## **Submission Objecting to State Significant Development Application SSD-119545240**

**40-76 William Street, Leichhardt**

Sheet title  
Overall Elevation - East & West

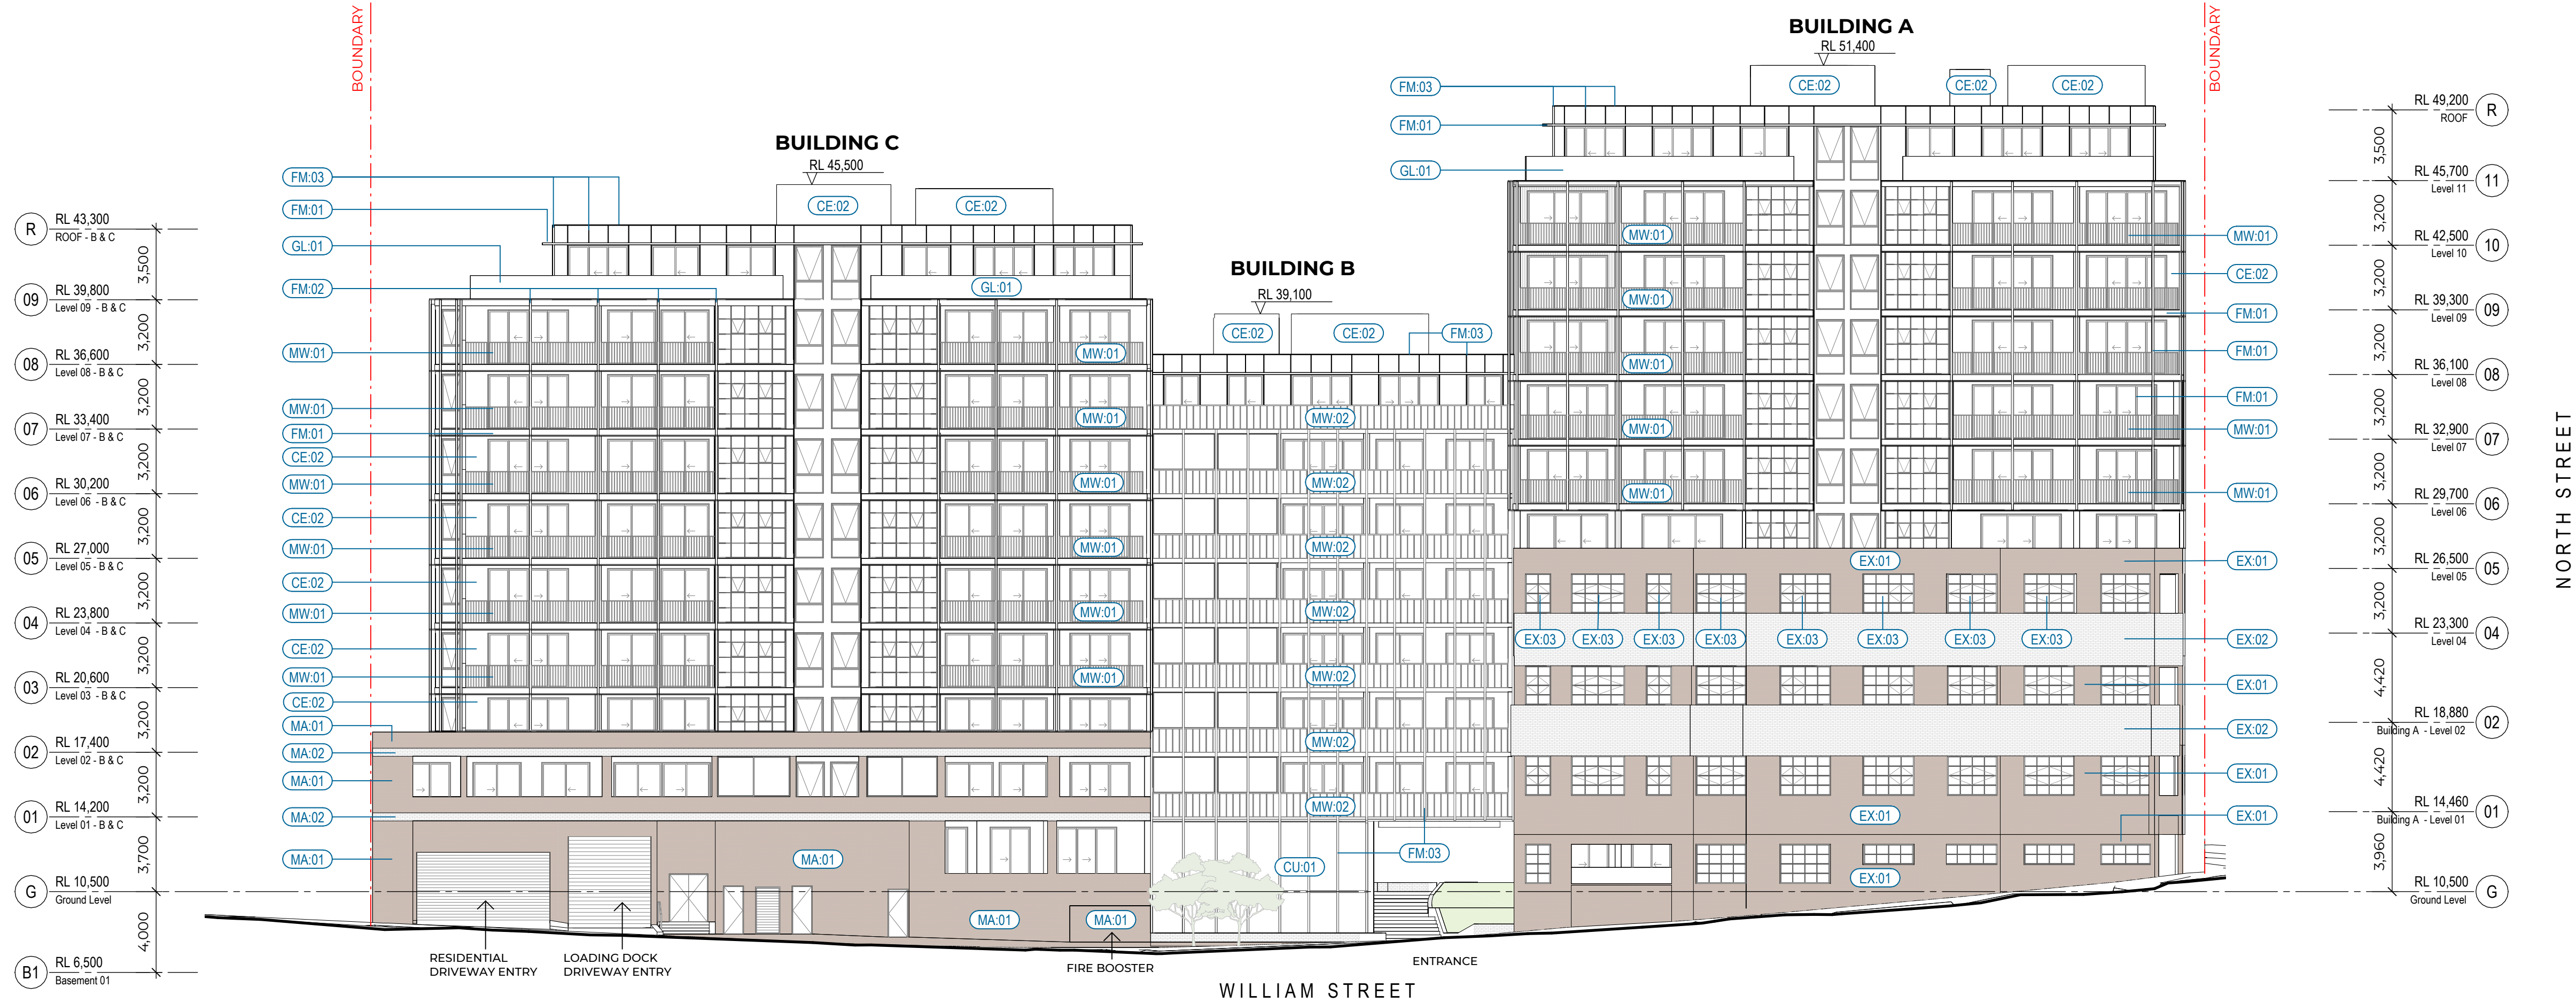
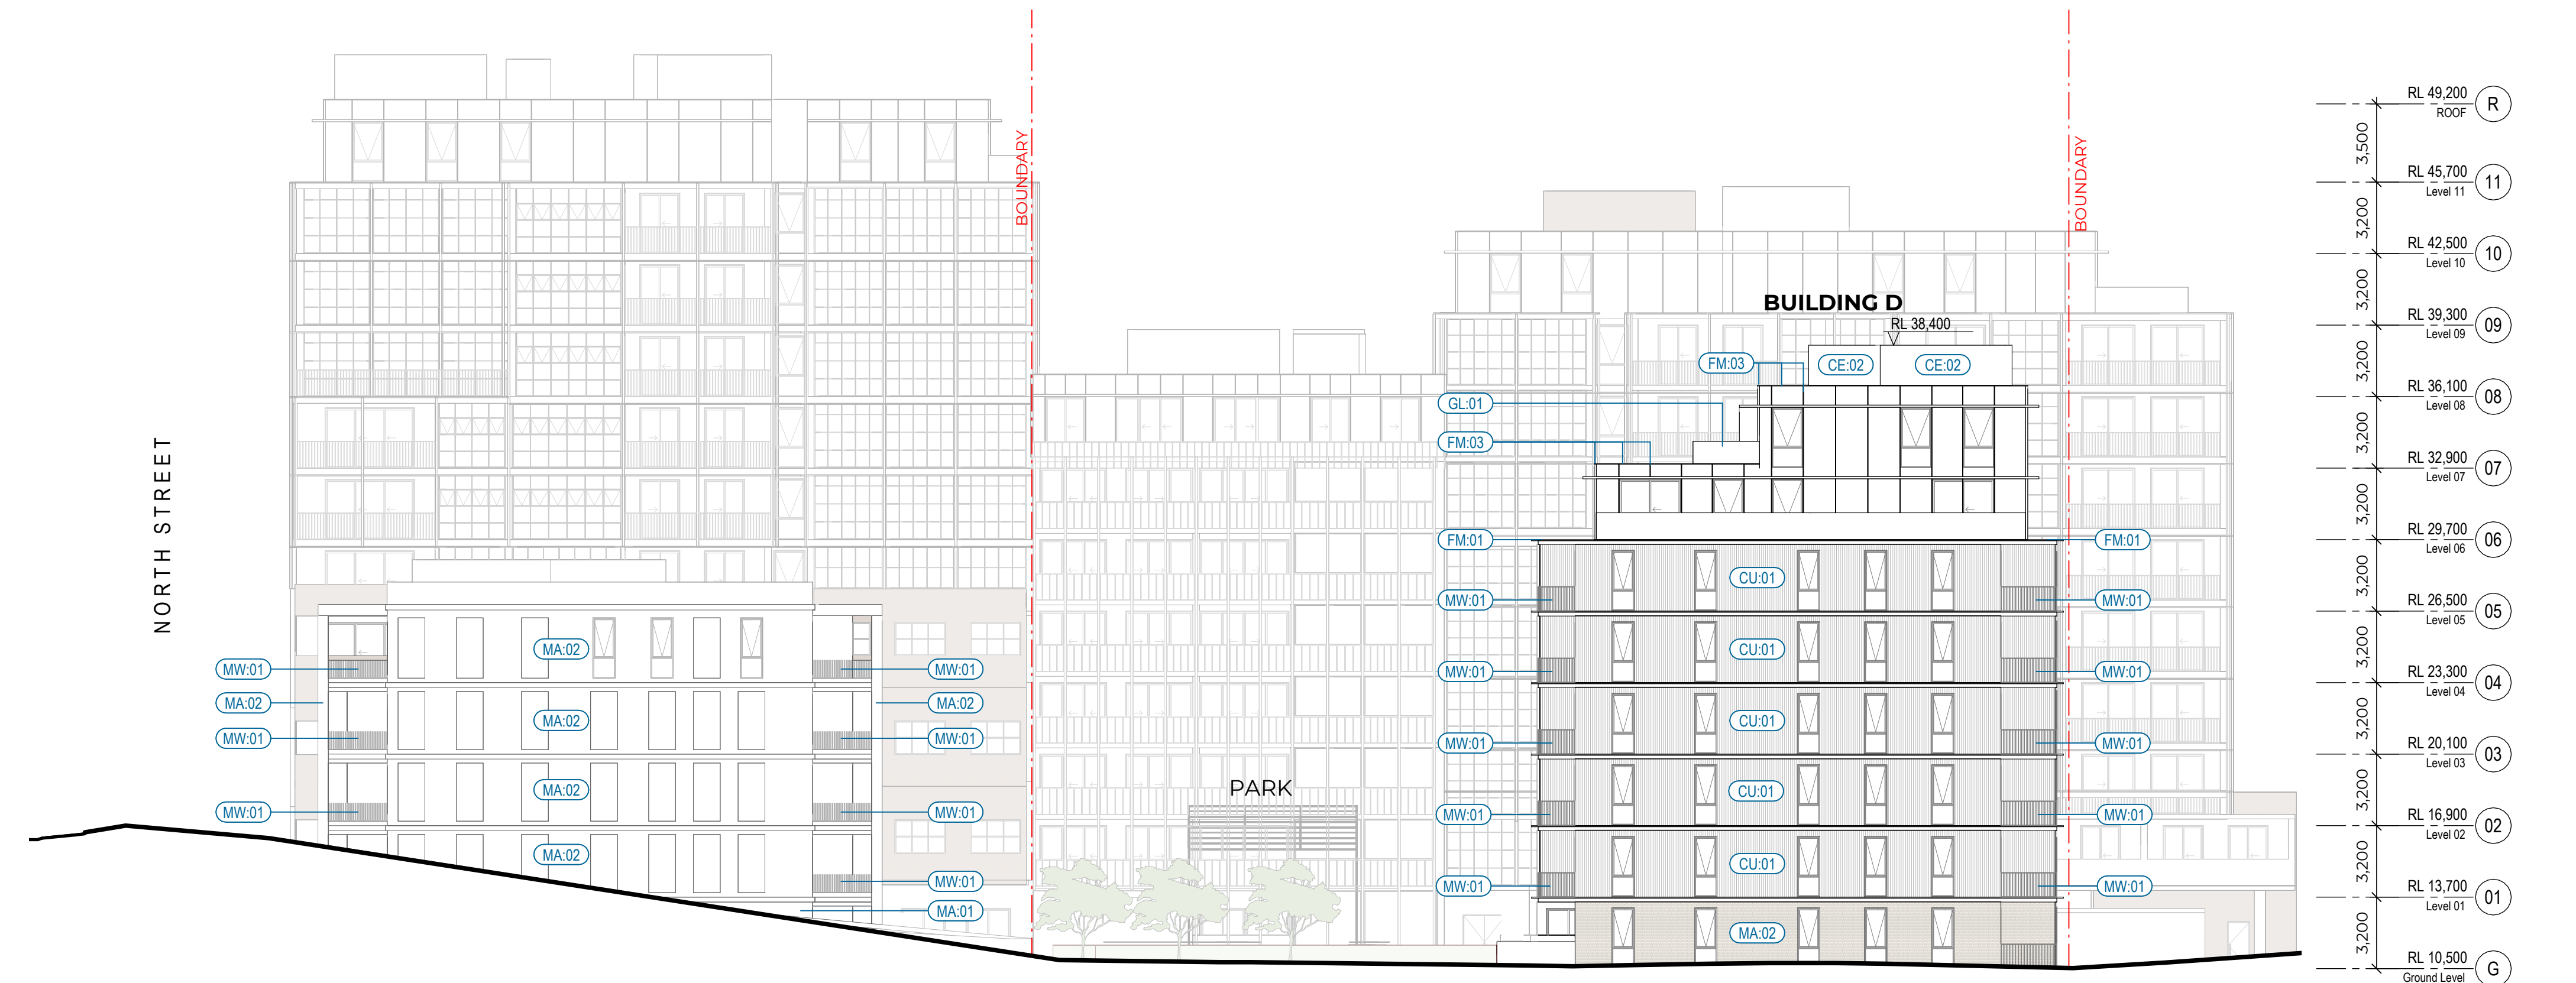
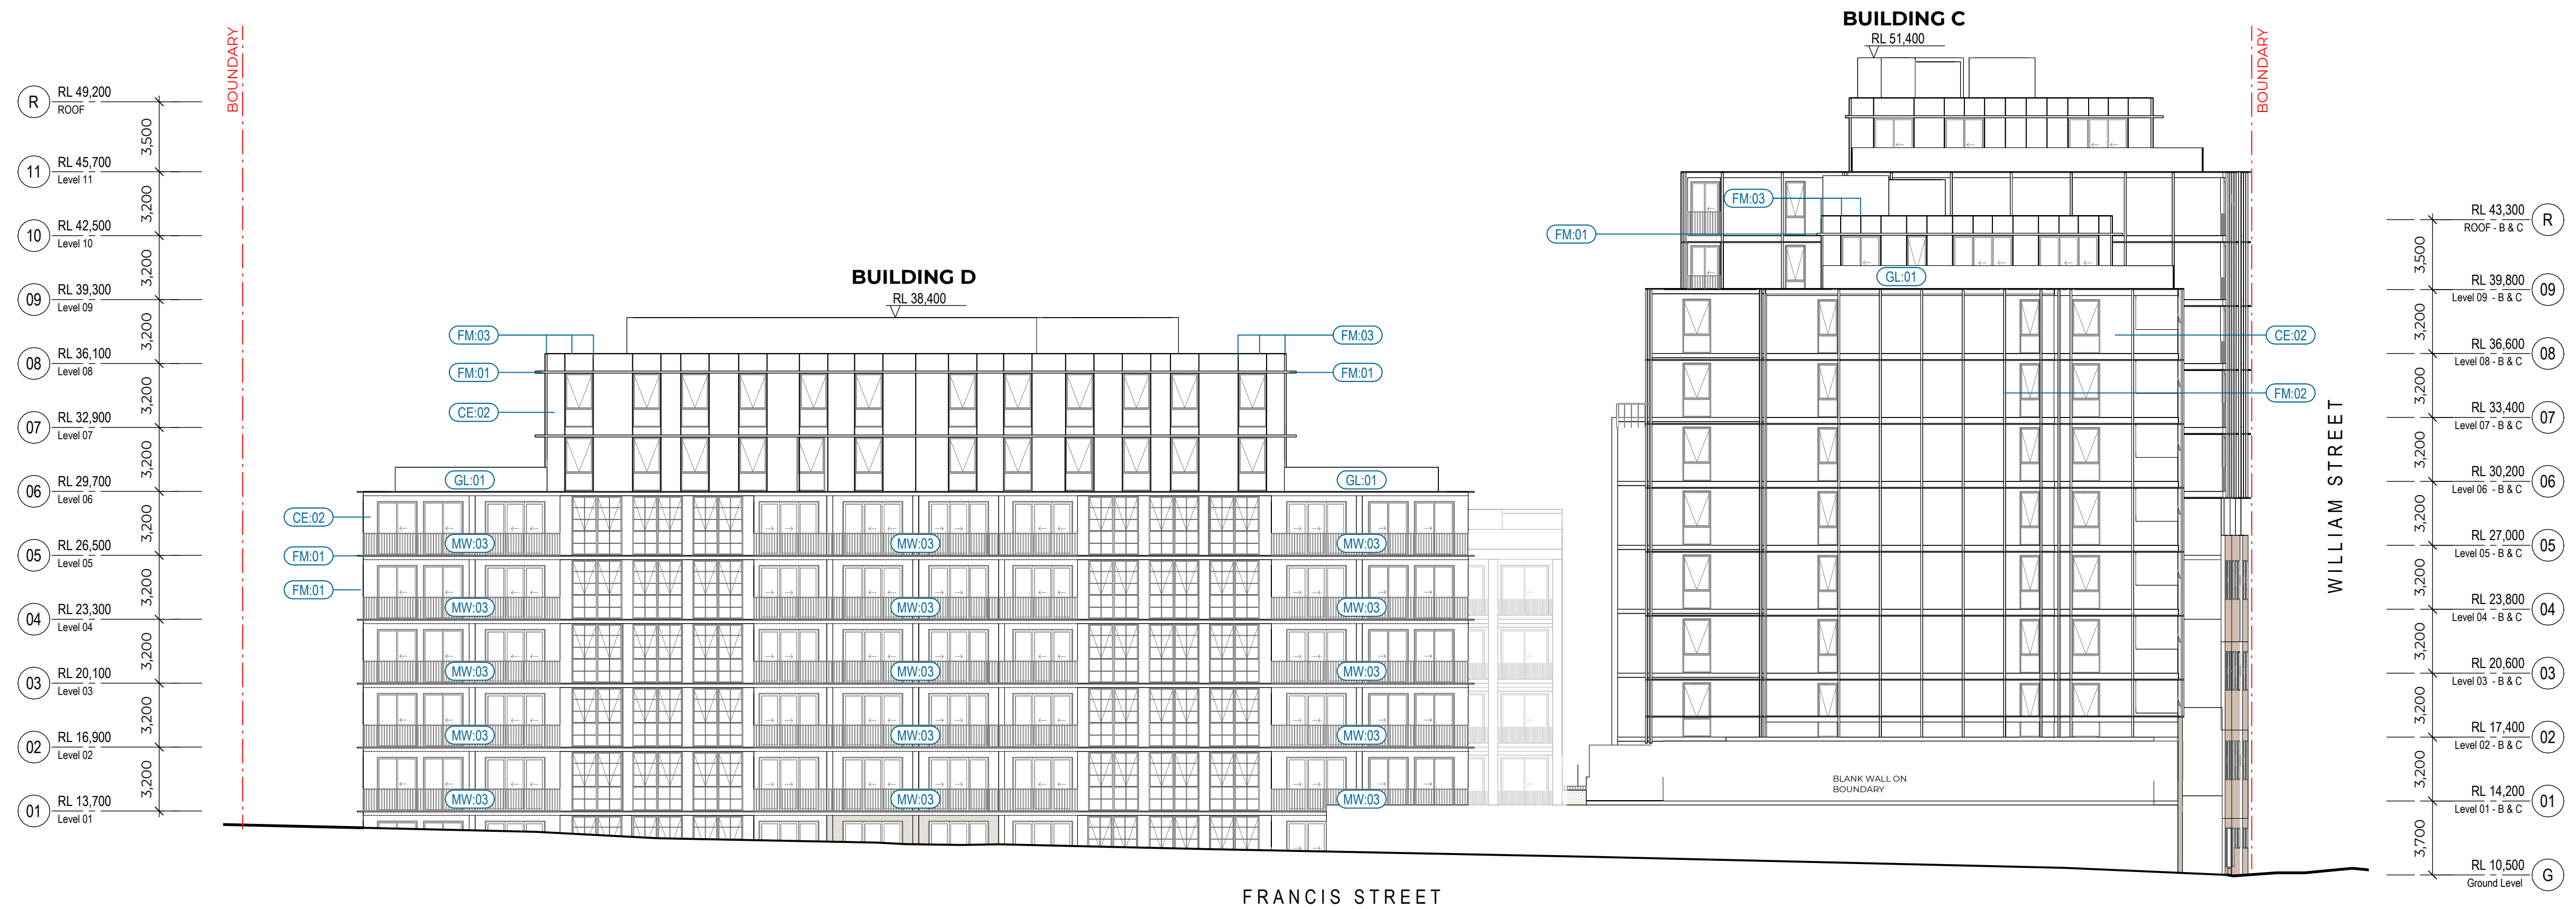
According to the submitted plans, the proposed development includes a building of approximately eleven storeys, considerably exceeding the prevailing height of surrounding development. The difference in scale would have a substantial impact on the character of the street and would be visually inconsistent with the existing low-rise heritage environment.

If redevelopment of the site is considered appropriate, the built form should respond more closely to its context. In particular, the height should be substantially reduced and should not exceed the scale of the existing building on the site, which I understand to be approximately four storeys.

I also note that a small terrace has nowhere to hide from buildings that tall. Buildings of 11 storeys loom over our small terraces, meaning people can see directly into our courtyards and living rooms. I have attached a photo of what the terraces look like in this area. You can't possibly think having 11 storeys looming over these terraces is appropriate.

- Fixed privacy screening and hoods on every window and opening that faces Francis Street and the terraces, so people are not looked down into.
- No balconies on the faces of the building that look towards Francis Street and the terraces, since balconies are where the overlooking happens. All other balconies to be deeper with planter boxes.

- A substantial reduction in the overall height and bulk of the development.
- A built form that better reflects the scale and heritage character of the surrounding streetscape.
